STERLING RANCH FILING 3
STREET IMPROVEMENT PLAN

SHEET 10 OF 13
JOB NO. 25188.00

EAST FL HAZLETT DRIVE PROFILE
STA 0+00.00 TO 1+49.12

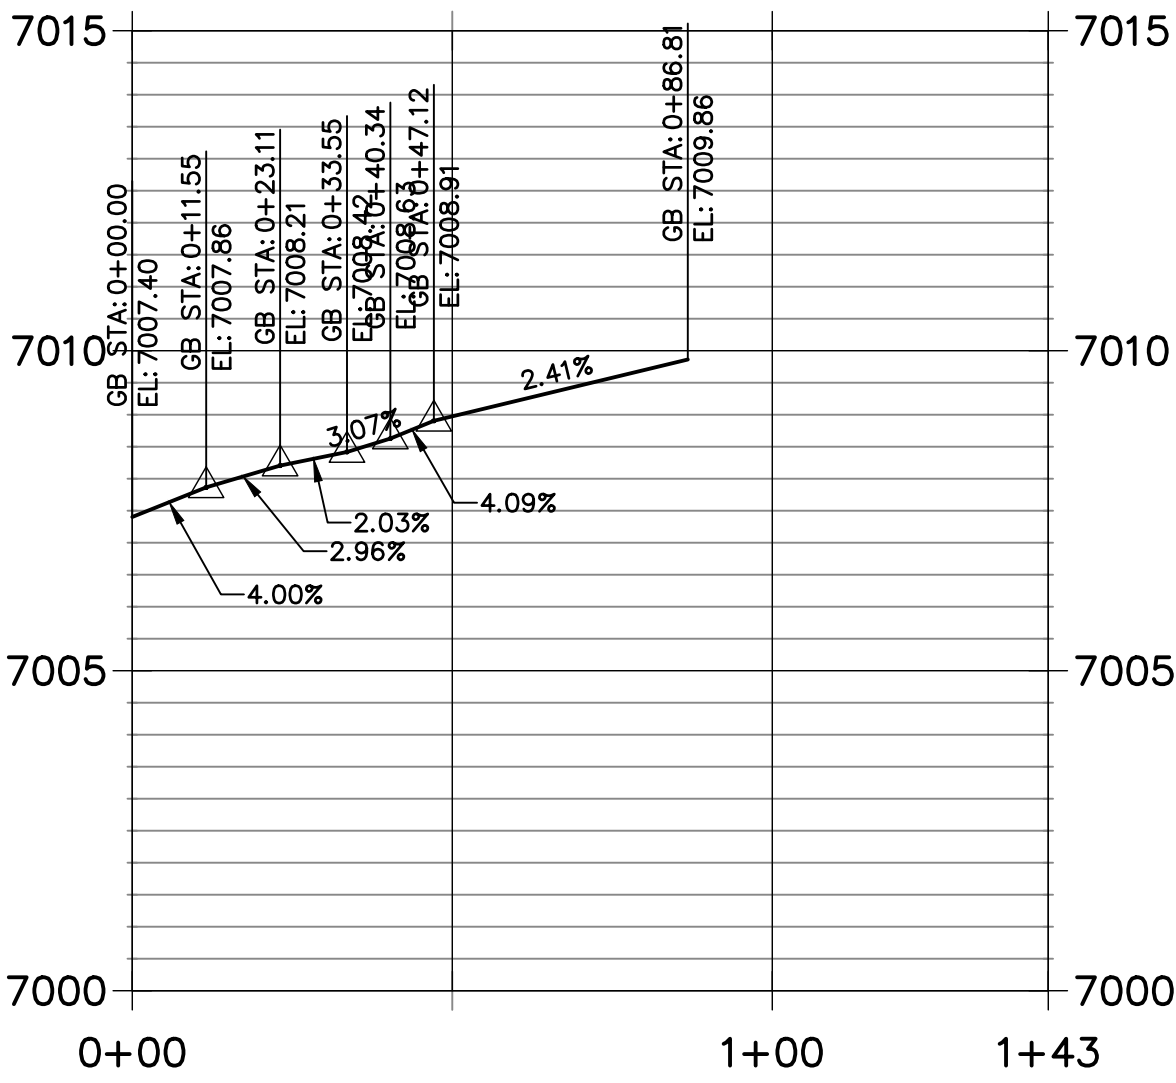
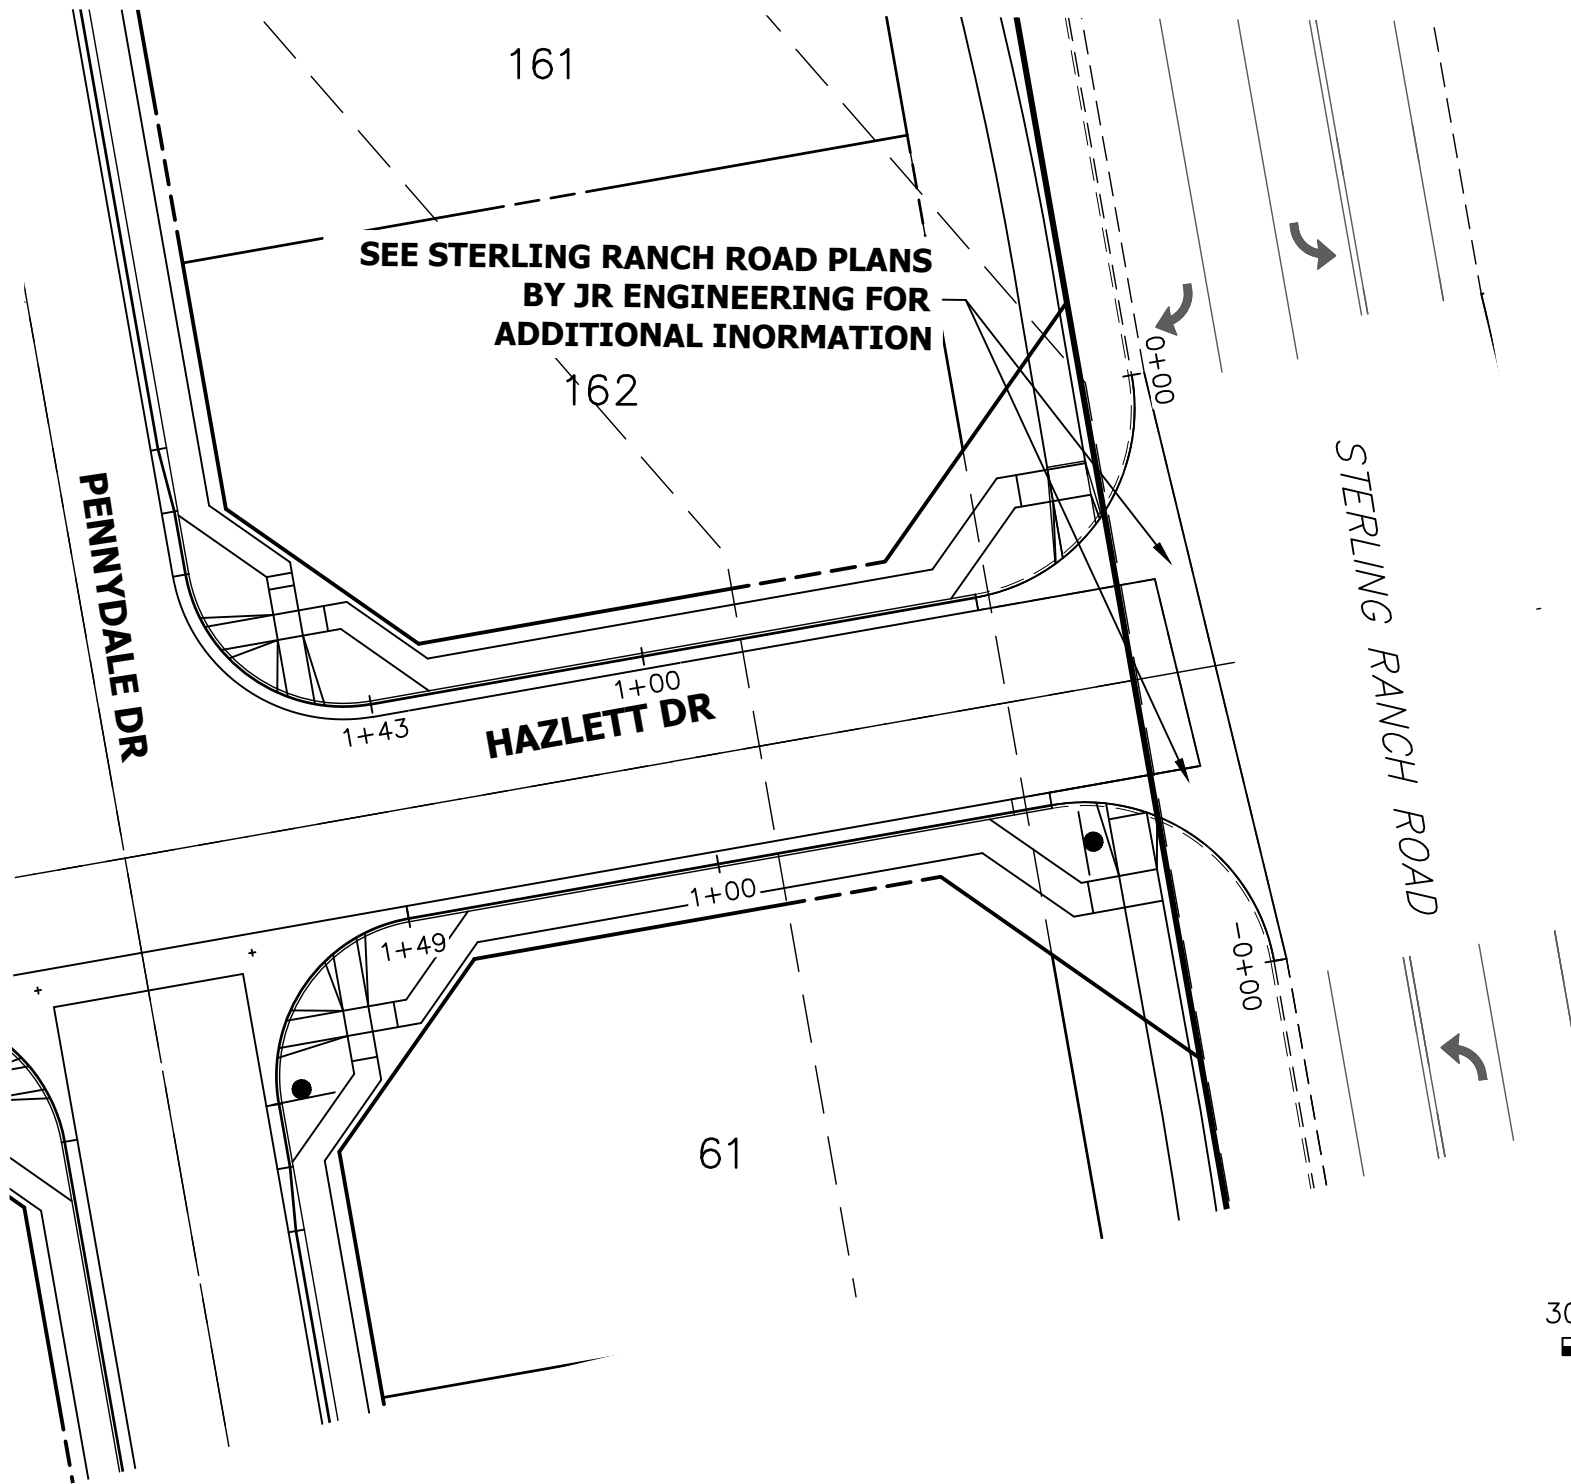
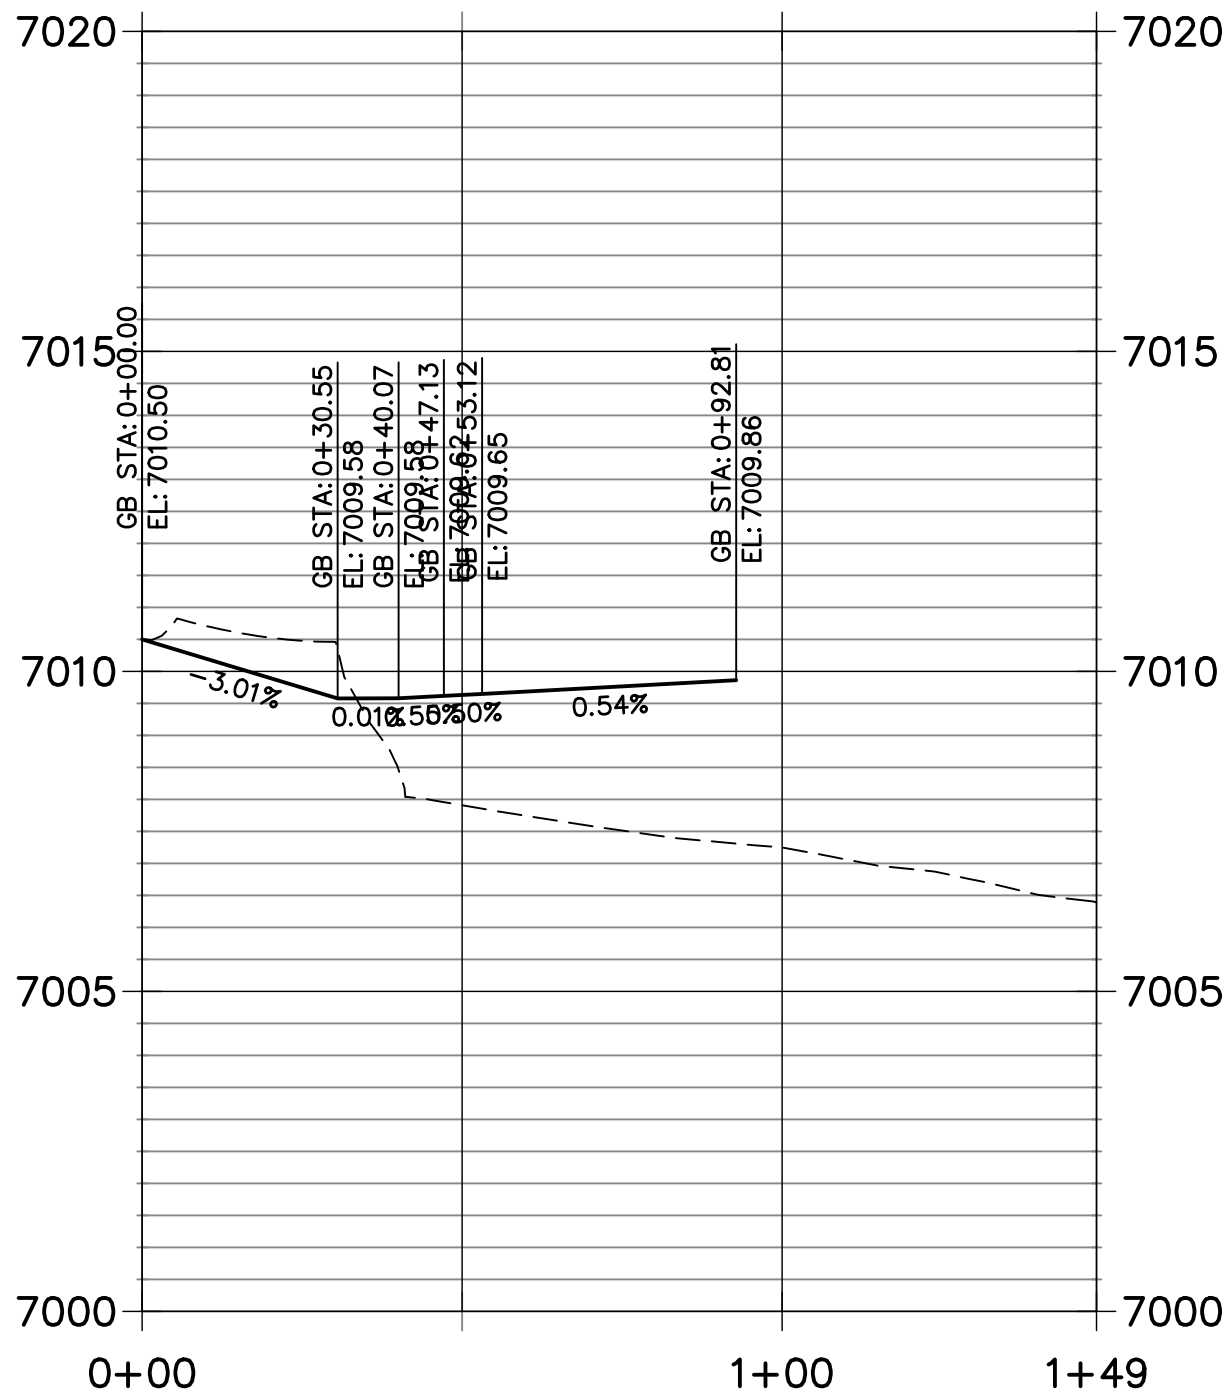
Please rotate the view to match the profiles.

SHEET 12	OF 13
JOB NO.	25188.00

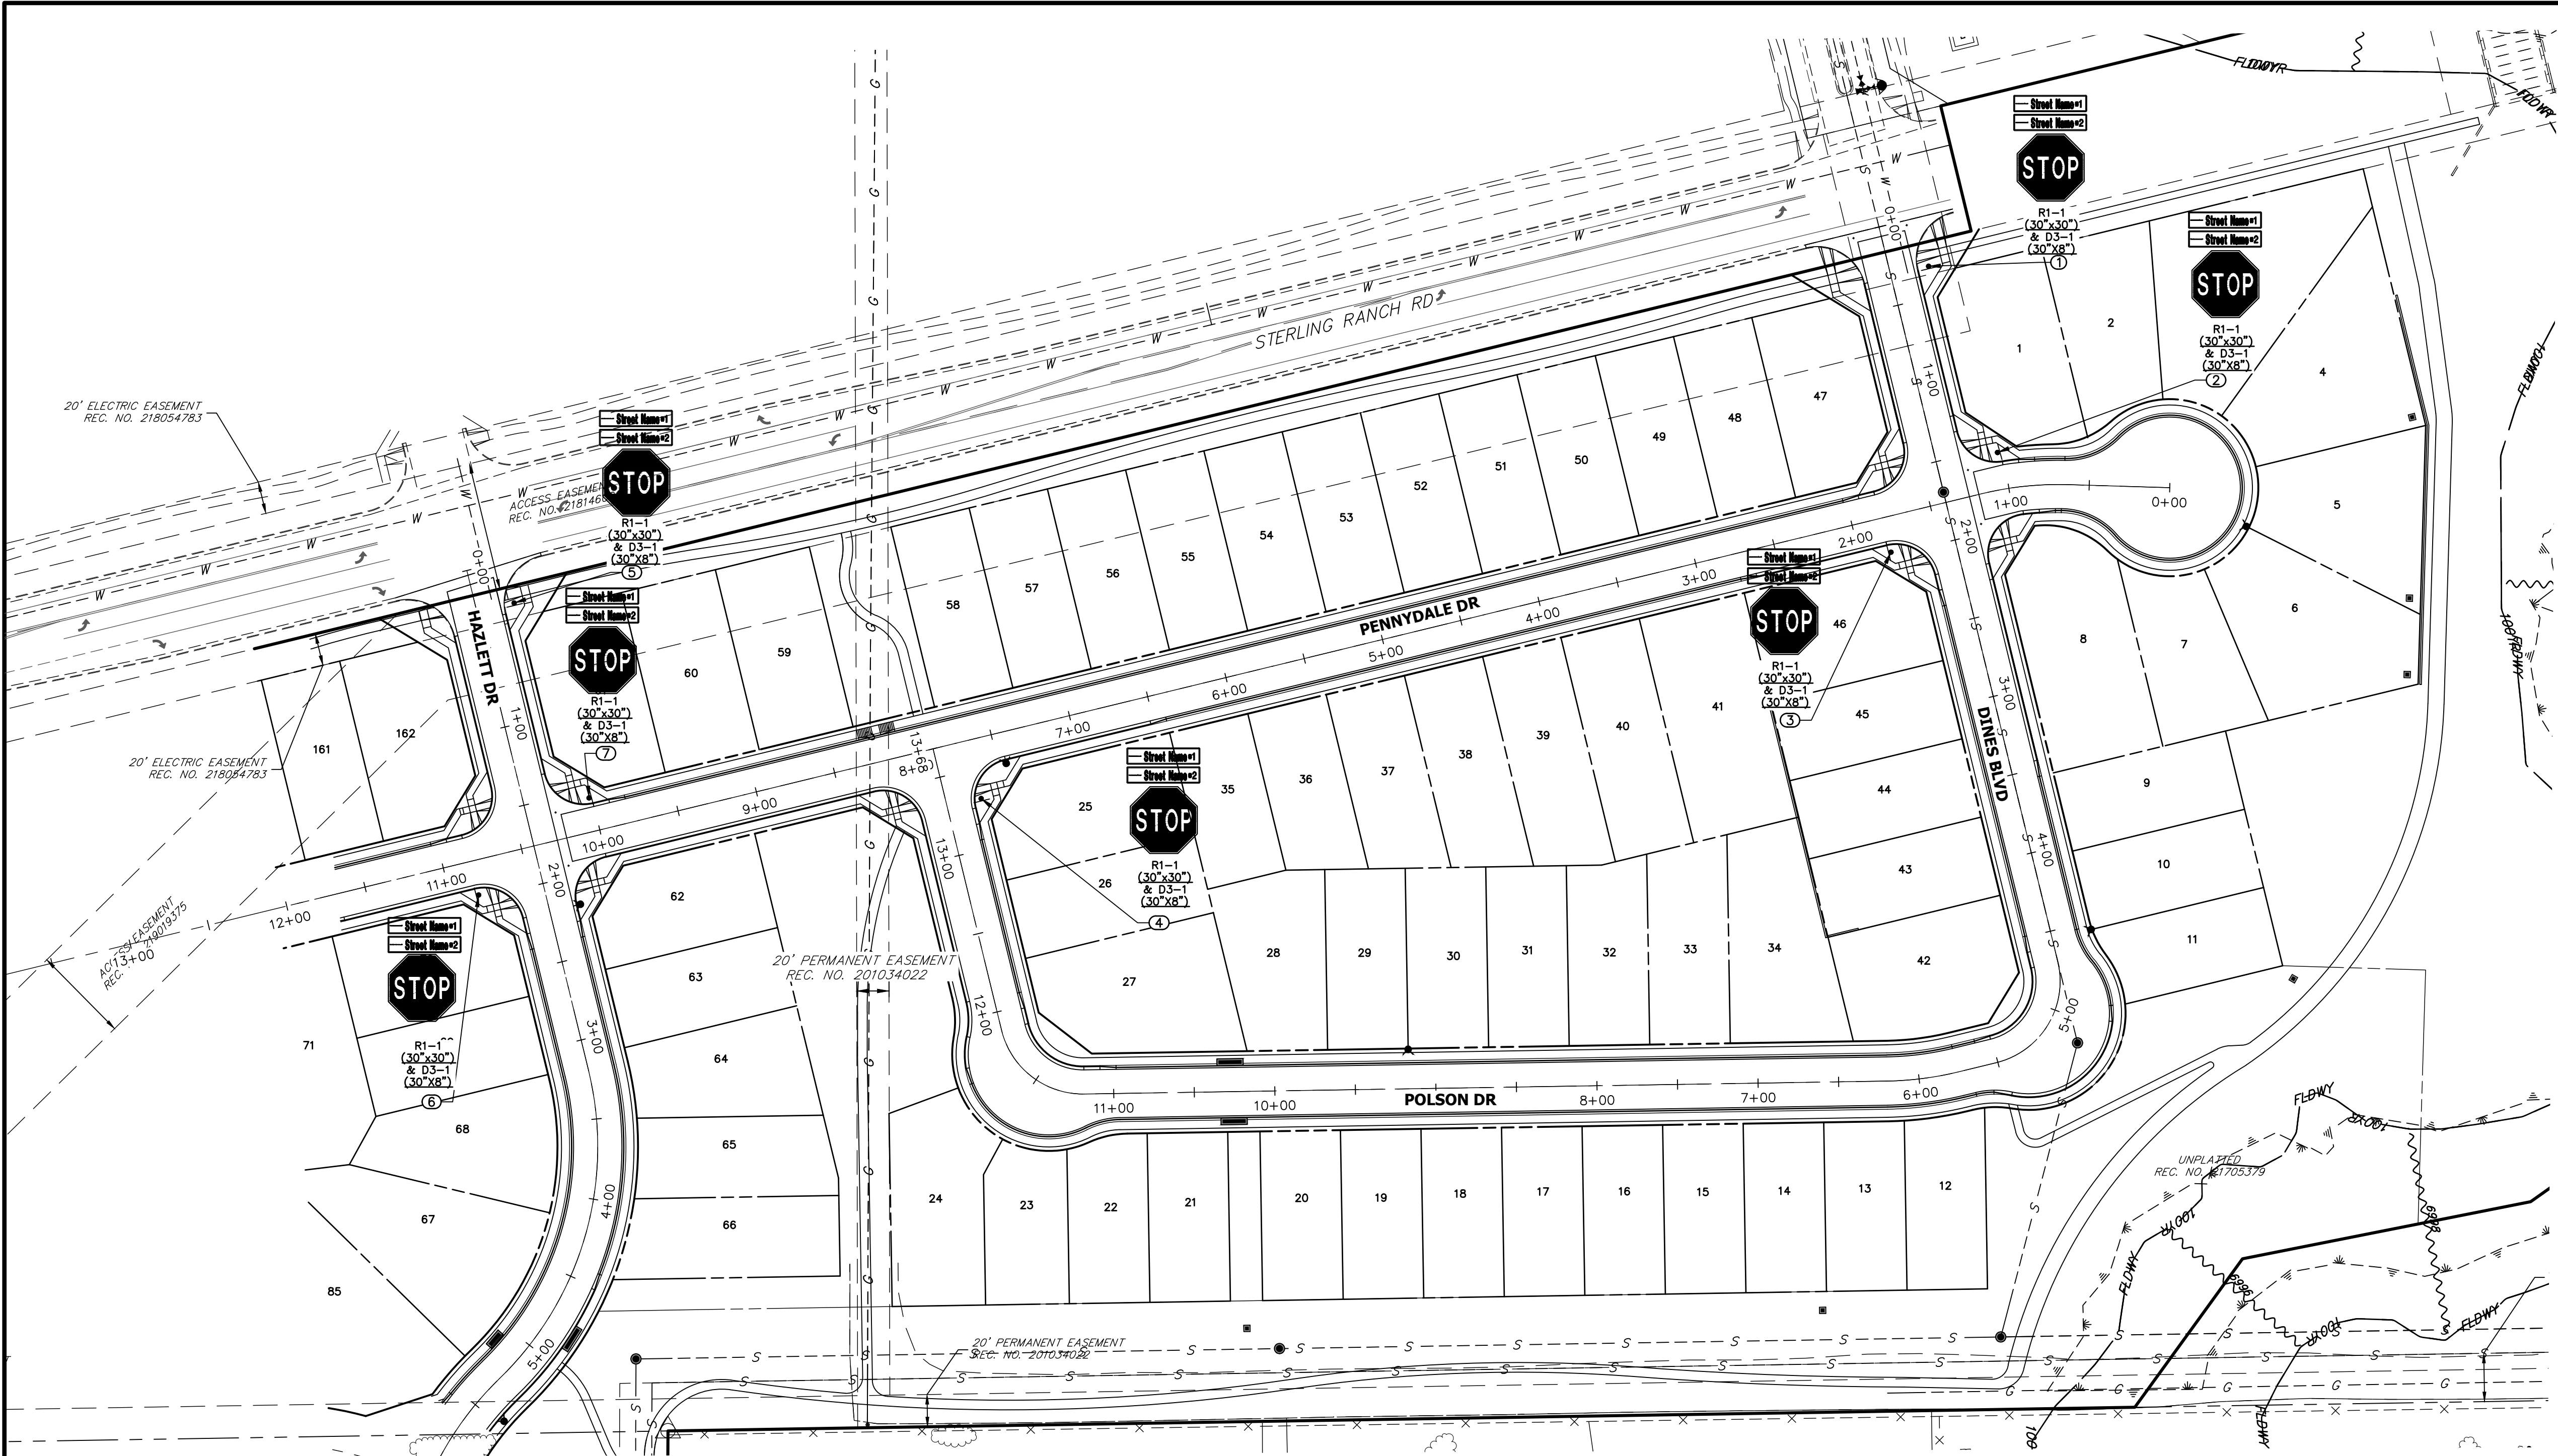
Lettering and abbreviations need to be per S&S std. note #7
